SYDNEY OLYMPIC PARK AUTHORITY DESIGN REVIEW PANEL – ADVICE SHEET

Project	Sites 2A and 2B – Australia Ave, Sydney Olympic Park	
Presentation / Review Date	31 October 2018	
Panel Present	Ingrid Mather Caroline Pidcock Michael Harrison	JMD Design (Chair) Pidcock Architects Architectus
COI Declaration	None	
Also Present	Alix Carpenter, Ben Woods, Dylan Sargent and Catherine Modini (SOPA) Daniel West and Candice Pon (Ethos Urban) Bassam Afflak and Michael Azar (Ecove)	
Presenters	James Fitzpatrick (Fitzpatrick + Partners) Matthew Mar (Fitzpatrick + Partners) Michael Barnett (Arcadia)

FACADE PLAN - 2A TOWER - TYPICAL HOTEL (NTS)
* STRATA COMMERCIAL SIMILAR

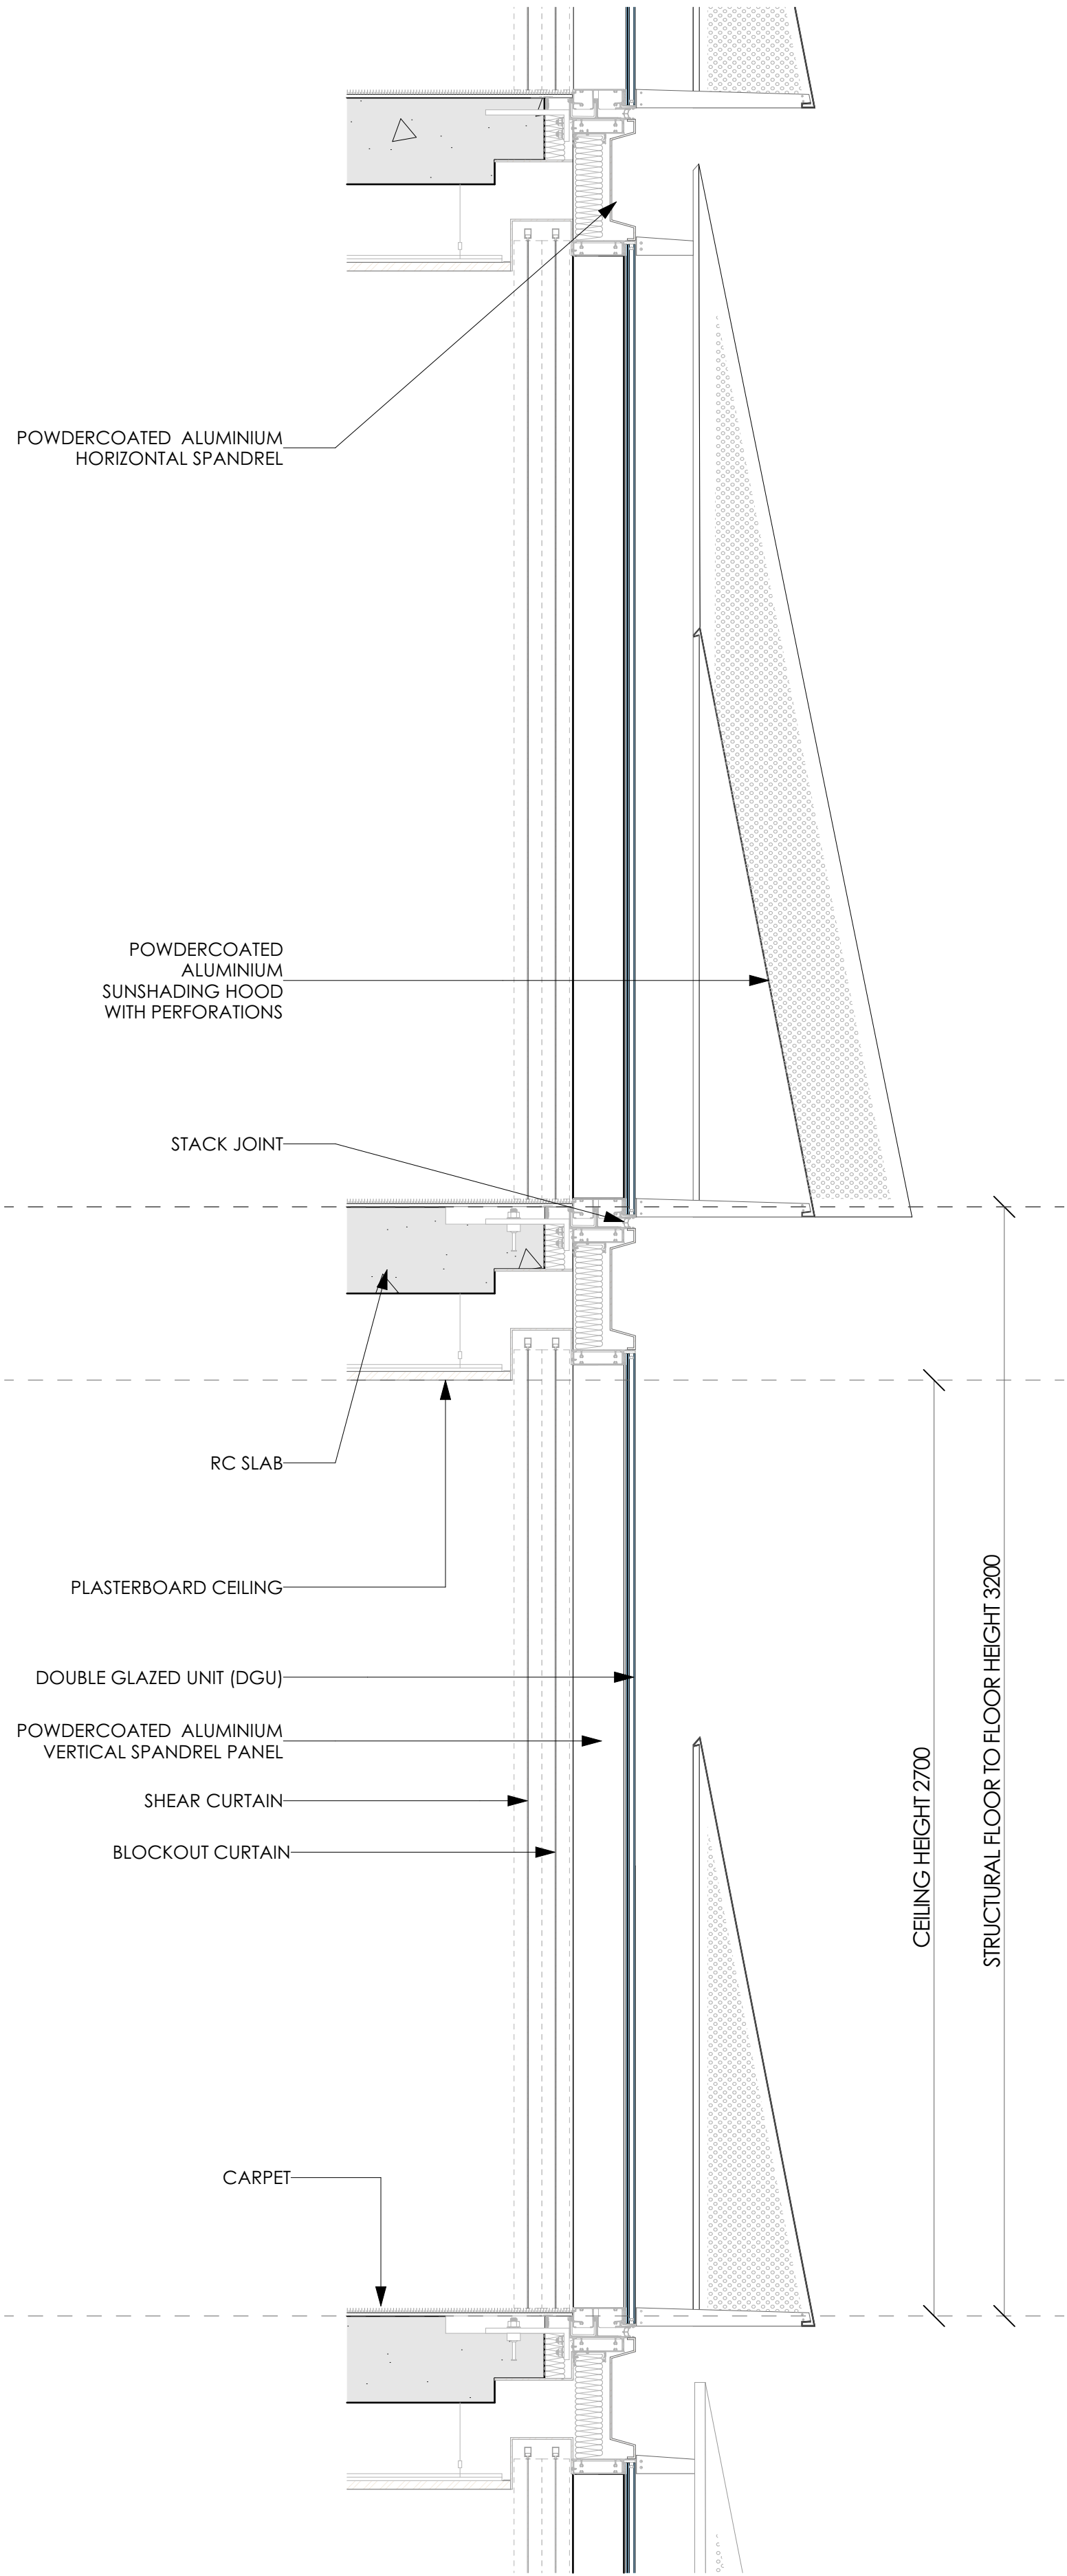
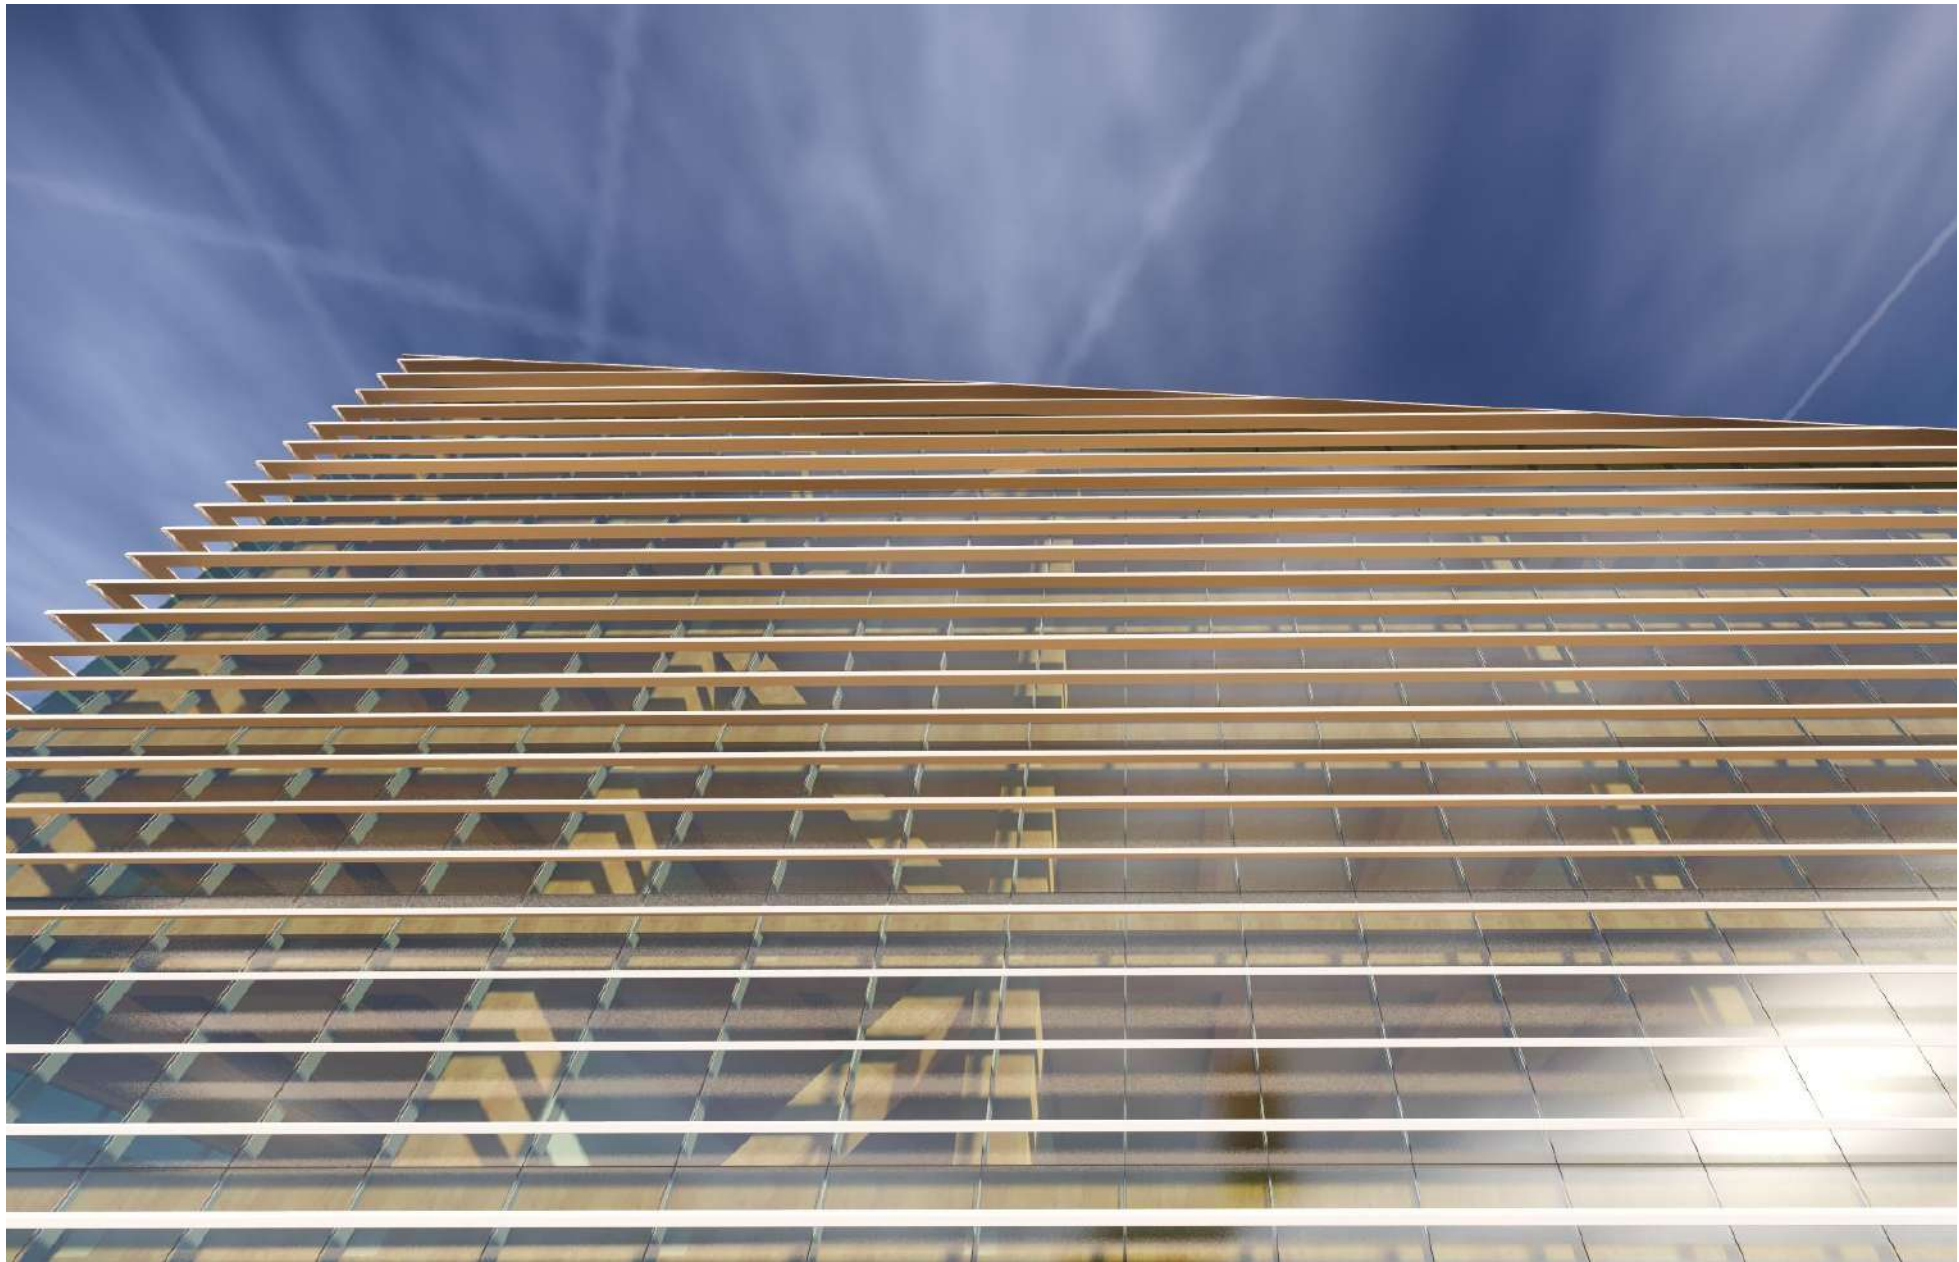
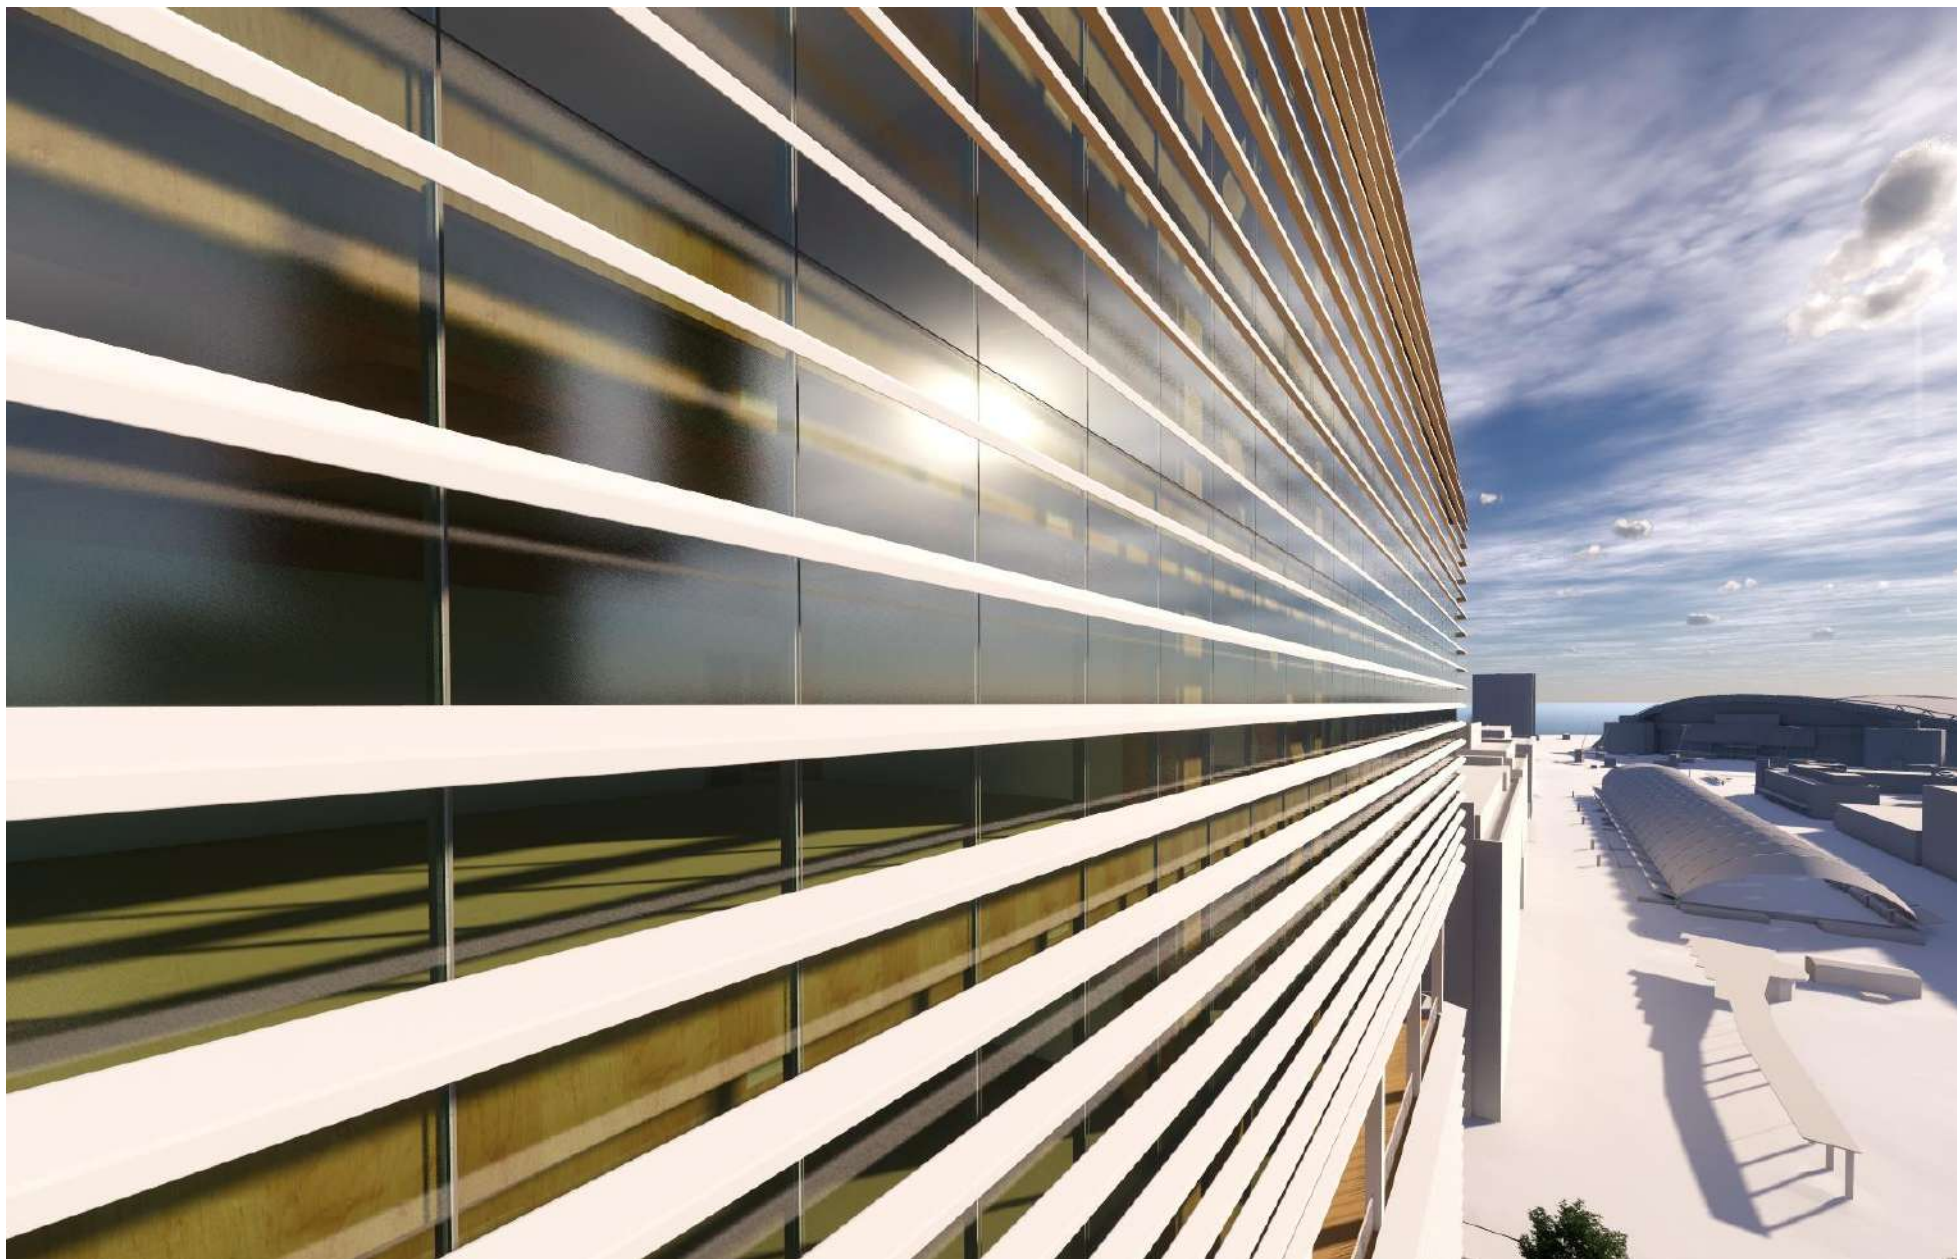
1. Façade design and solar performance:

Fitzpatrick + Partners presented a modified façade design, which included:

- a façade module around the perimeter of the tower, with equal floor to floor heights to create consistent panel geometry;
- flipping the panel geometry so that the solid triangular panels are pointed down and glass triangular panels are pointed up; and
- introduction of diagonal sunhood elements to the facades, which would vary between a consistent 150mm width on the southern facade and a tapered width of 150mm-450mm on the northern and western facades to optimise solar performance and reduce heat loading.

1. The Panel supported the design development of the façade and recommended that further development continue to be undertaken to optimise solar performance.
2. The Panel supported the decision not to include an outlook or natural lighting from lift foyers but resolved that the internal hallway design concepts needed to be further developed. In particular,
